**From:** William Clark  
**To:** Jean Fraser  
**CC:** David Margolis-Pineo; Jennifer Thompson  
**Date:** 10/22/2015 2:22 PM  
**Subject:** Re: Fwd: 415 Subdivision Plat for PB - signoffs needed (2015-162) - Plan Needs Attention  
**Attachments:** Cumberland Ave No 415 Draft Plat 10.14.15 Survey Review 10 22 2015.PDF

This project is the conversion of offices into 10 residential units and requires a subdivision plat. The Plat will be reviewed and approved by the Planning Board on Nov 10th, but if I could get your signoffs on this within a week then the street tree note re a waiver/contribution could be added and the mylar could be signed at the PB meeting (not the end of the world if this can't happen). Its a relatively simple project and the attached plat reflects my input; I won't be recommending any subdivision conditions.

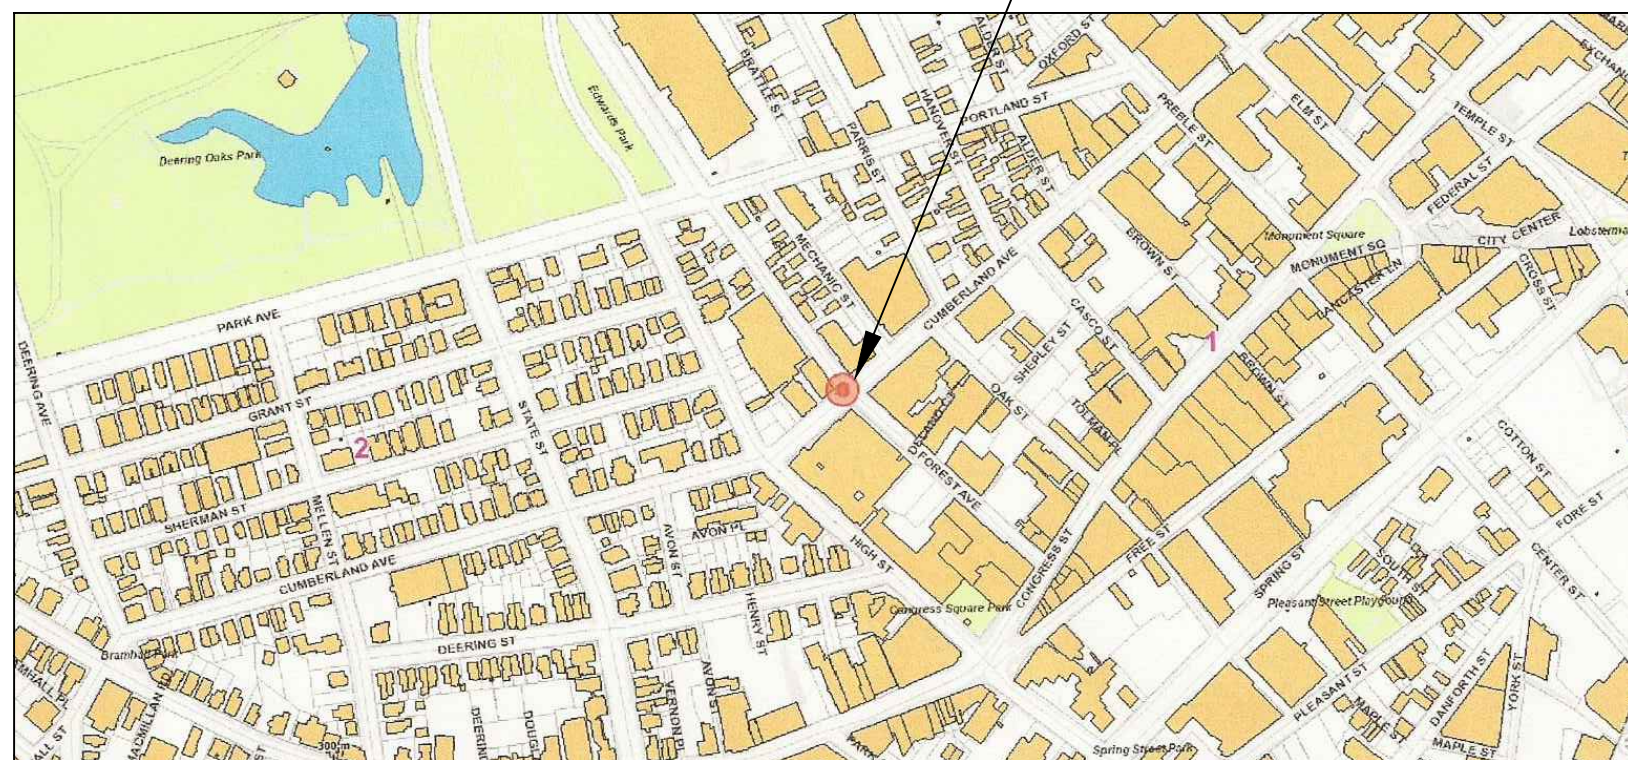
1. Easements need to be correctly defined on the plan with bearings and distances. The easements were drafted in 1925 before the YMCA building was constructed, and need to reflect what is on the ground. The Condominium Association will need to have the easements defined and the nature of the easements stated.

2. Incorrect Easement Deed Reference. CCRD Deed Book 3019, Page 133 is for a Tax Lien Discharge in Cumberland , Maine.
3. Text "Existing Easement Area book 1212, Page 217" points to the easement area for easement in Deed Book 1212, Page 215.

4. Coordinates are not correct for the two points listed along Forest Ave.
5. Elevations are not correct for the two points listed along Forest Ave.
6. Need to set property corners.

7. Coordinate System. NAD83?  
The City of Portland coordinate system is NAD83 HARN Maine State Plane: West Zone (FIPS 1802) US Survey Feet
8. Vertical Datum. Which City of Portland official benchmark was used?

9. "Lotus Map". I believe this should be "Locus Map".
